# CITY OF ALBUQUERQUE

August 9, 2023

**Re: Traffic Impact Analysis for Tramway Starbucks**  
**Traffic Impact Analysis draft, dated July 2023**  
**HT#L23D015A**  
**Engineering Seal date ---**

Figure 1: Site Plan

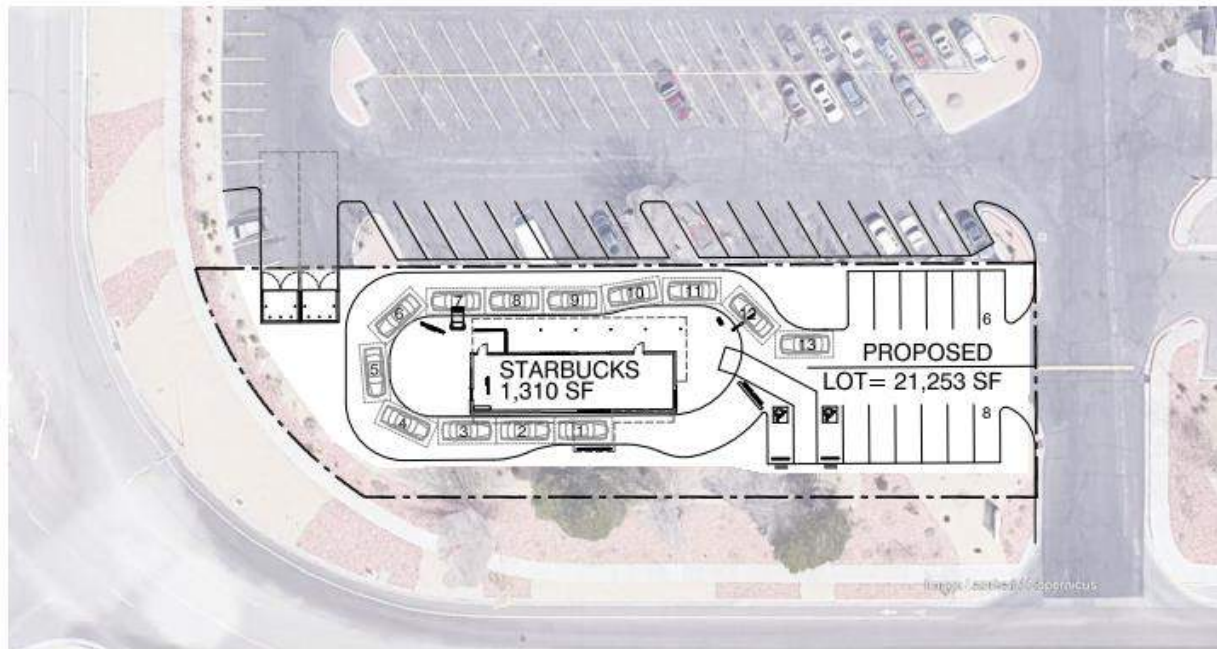
- The existing southbound left turn lane serving the site at the west driveway be lengthened to meet DPM design specifications as closely as possible.
